## KITTITAS COUNTY COMMUNITY DEVELOPMENT SERVICES

March 6, 2009

**RE: Firkins Short Plat (SP-08-00055)**

Kittitas County Community Development Services hereby grants **conditional preliminary approval** to the Firkins Short Plat (SP-08-00055), subject to the following conditions:

**FIRKINS SHORT PLAT**

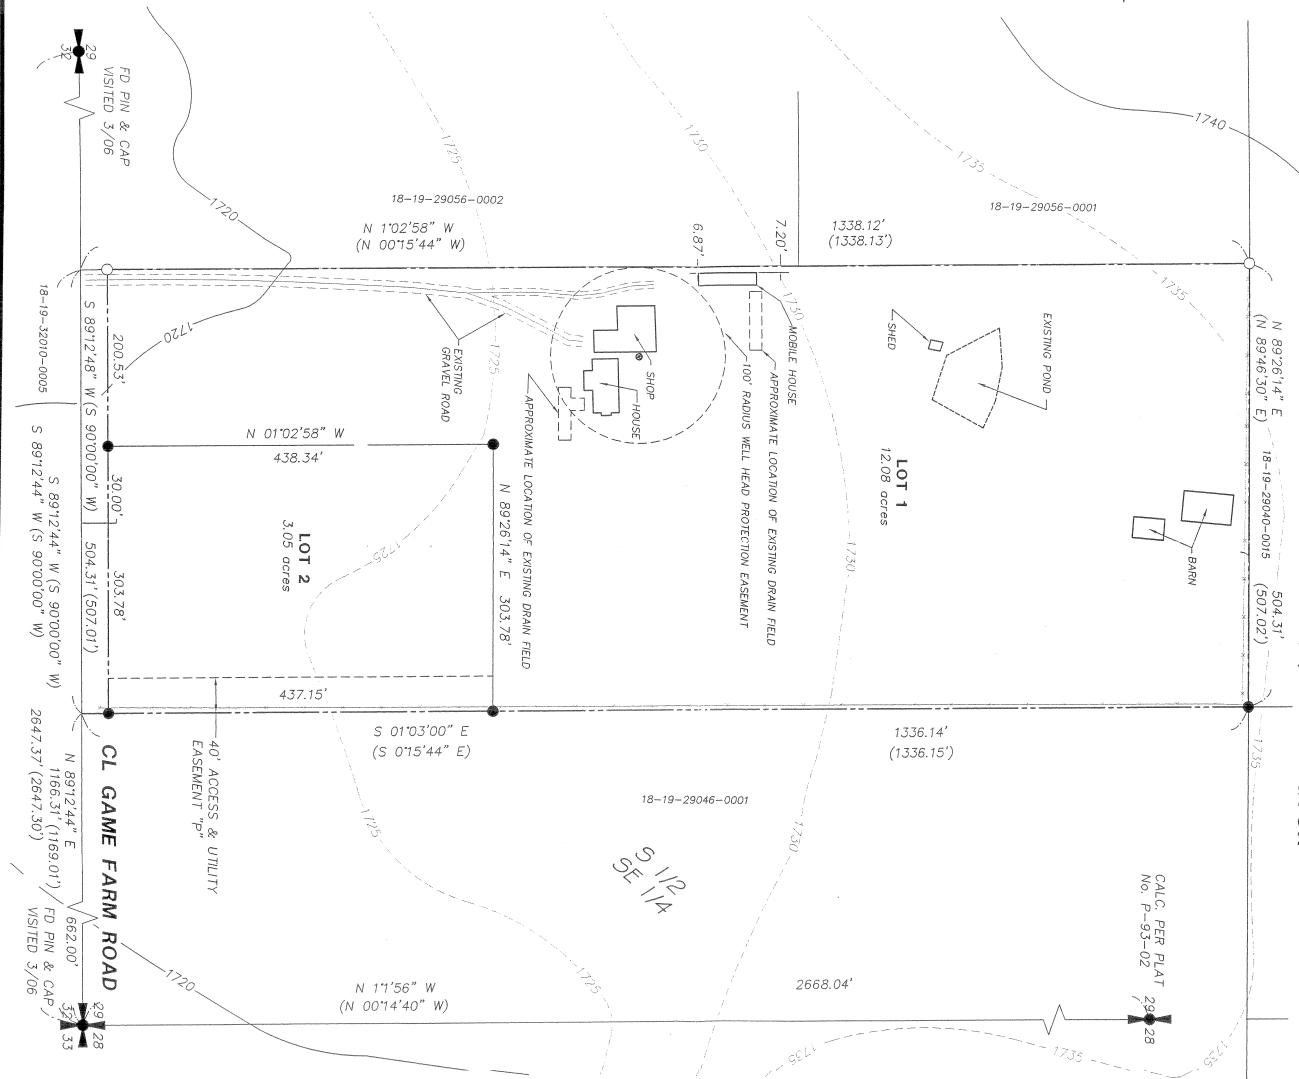
1. Both sheets of the final mylars shall reflect short plat number SP-08-00055 and an accurate legal description/map numbers shall be shown on the face of the final plat.

7. Water delivery via the existing Burke Ditch shall not be impaired.
